CITY OF ALBUQUERQUE

January 16, 2015

**RE: COA Transit Department Yale Maintenance
Grading Plan and Supplemental Calculations
Engineer's Stamp Date: none (File: L15D004)**

GRADING PLAN

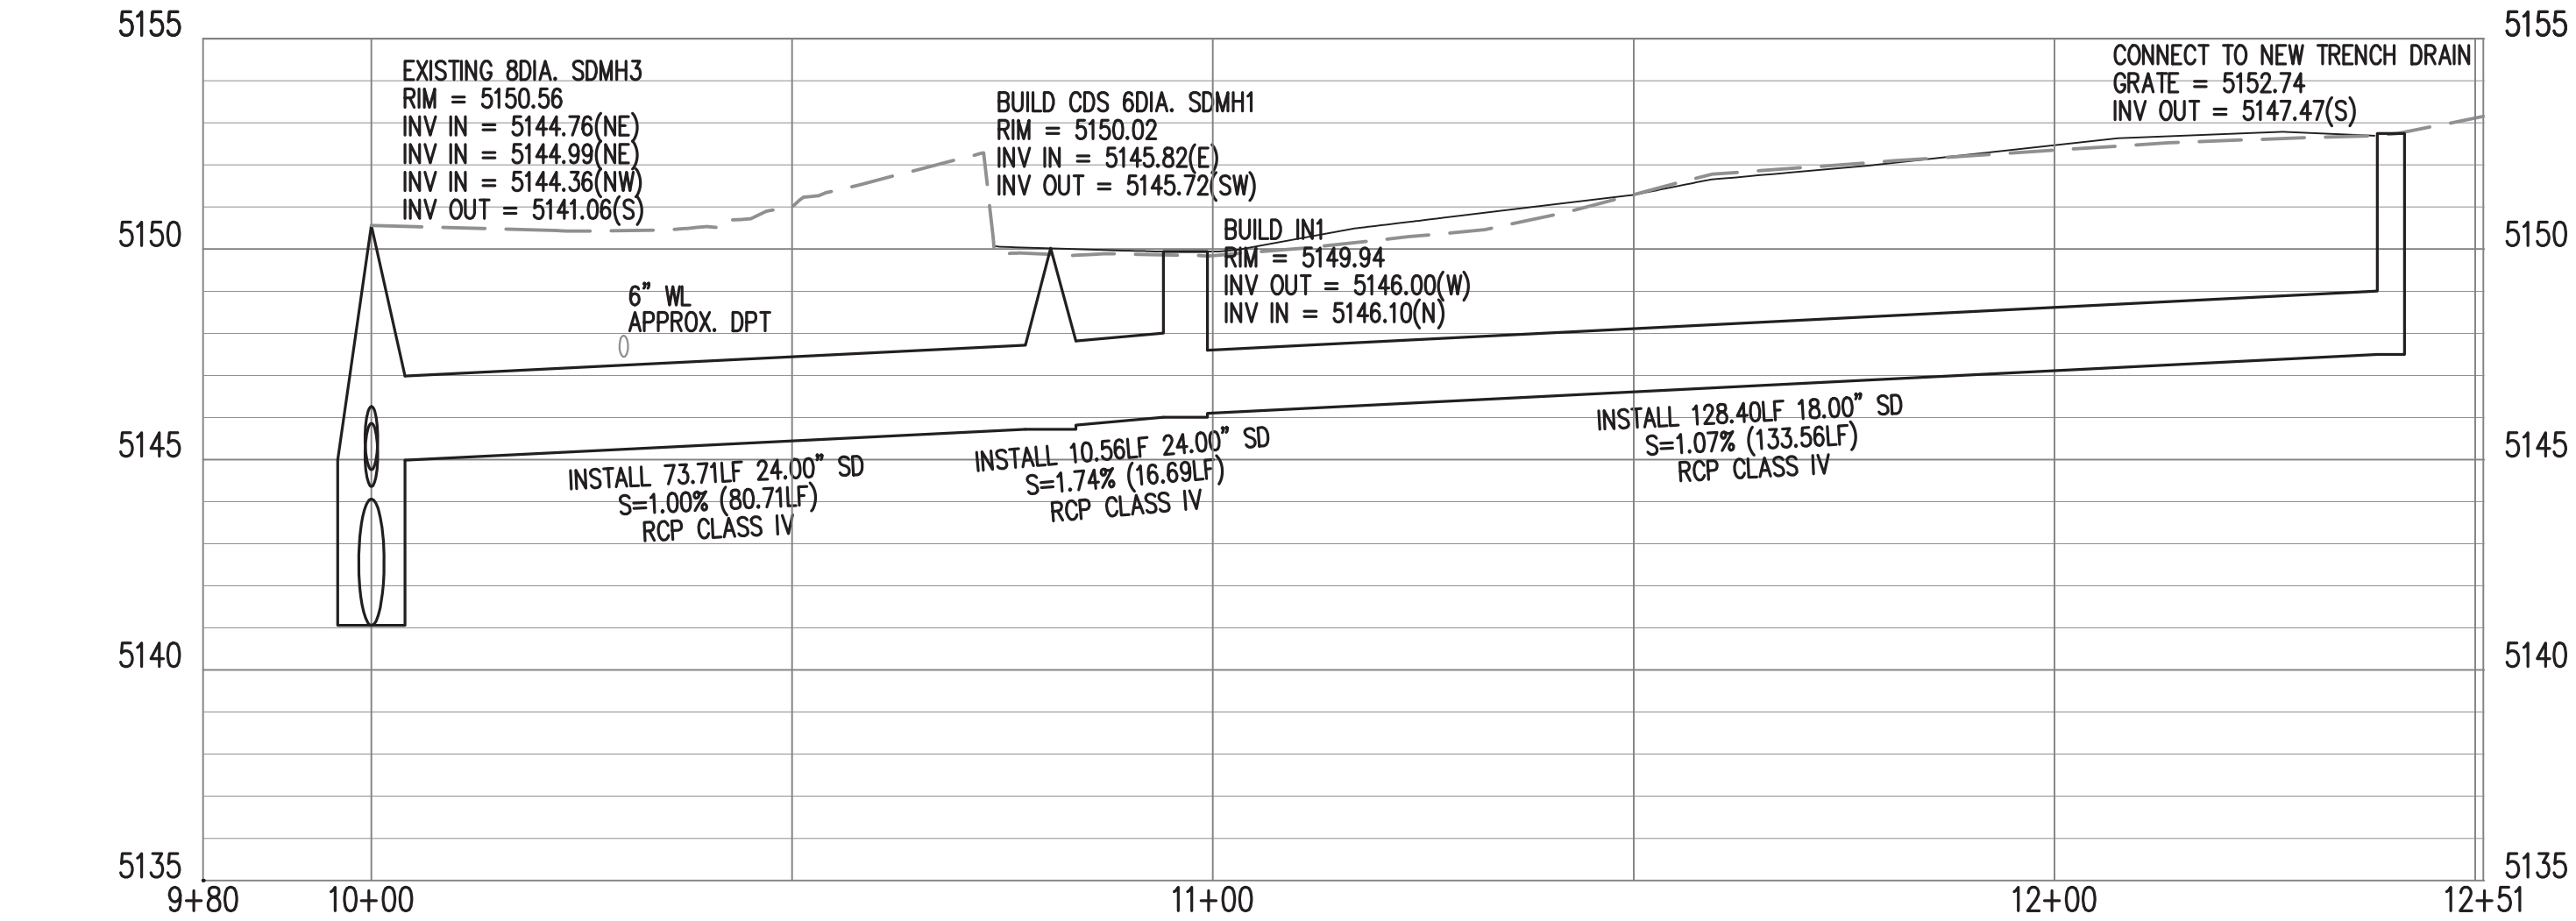
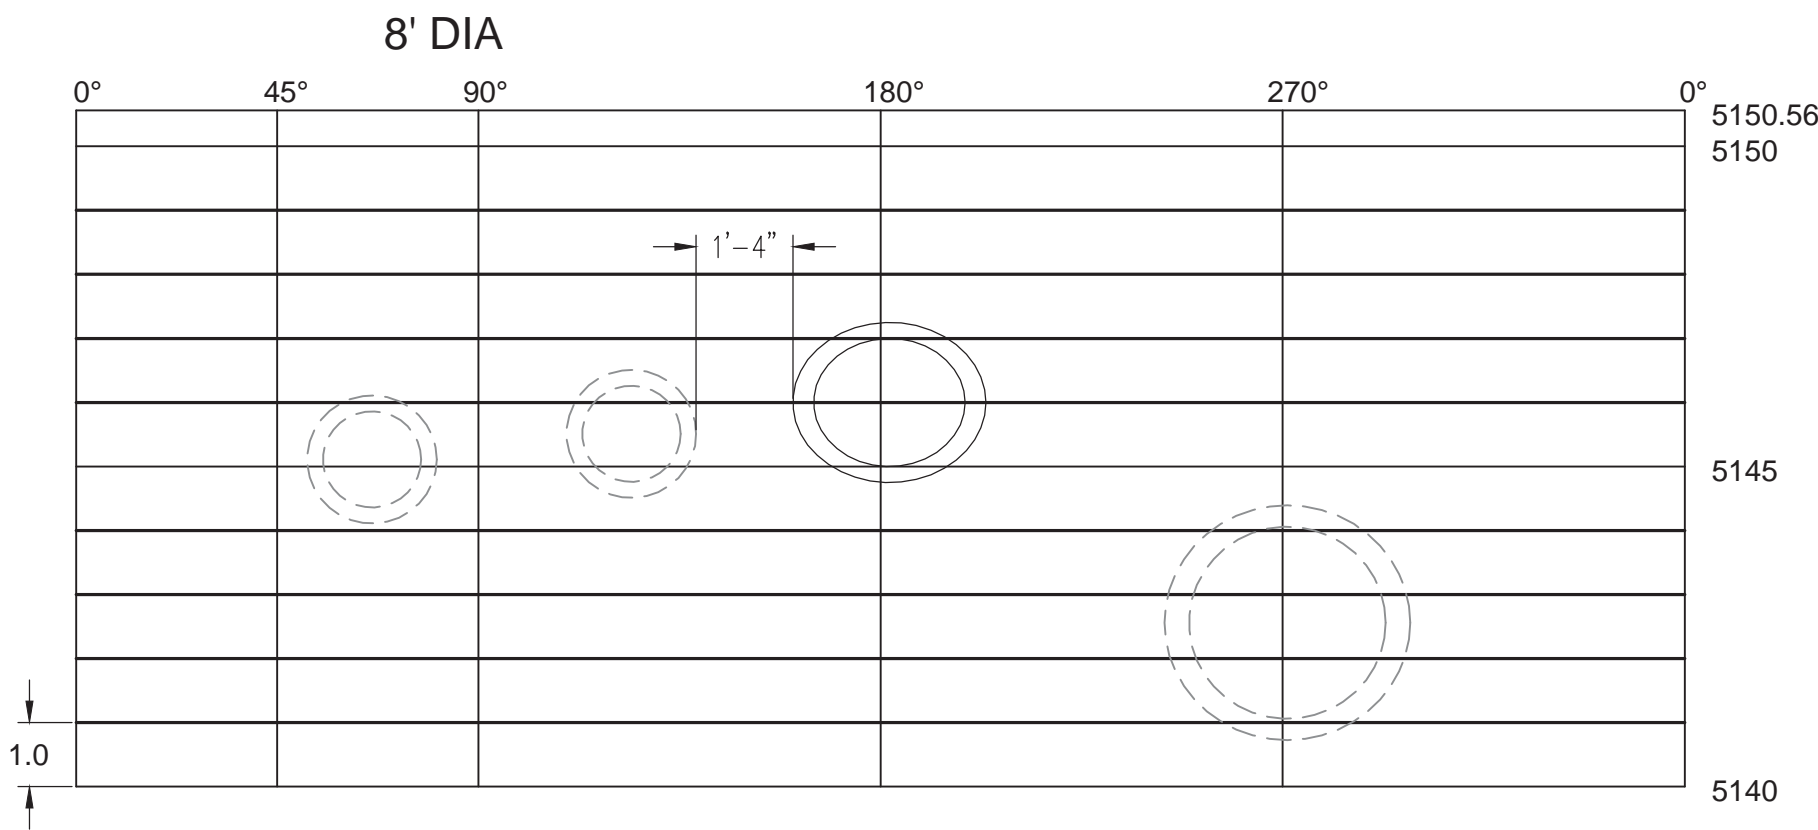
- Supplemental Calculations and Plans need to be stamped by an engineer
- Provide the Site Plan in the submittal for information.
- Bench mark data is required. State the datum used.
- What flows in Yale discharge to the SD in Bell. Supplemental calculations do not seem to address this. Please provide excerpts from previous studies. What flows are input into the Haestad Model? The output is provided, but not the input.
- Call out the type of Inlet (just before the Water Quality Manhole).
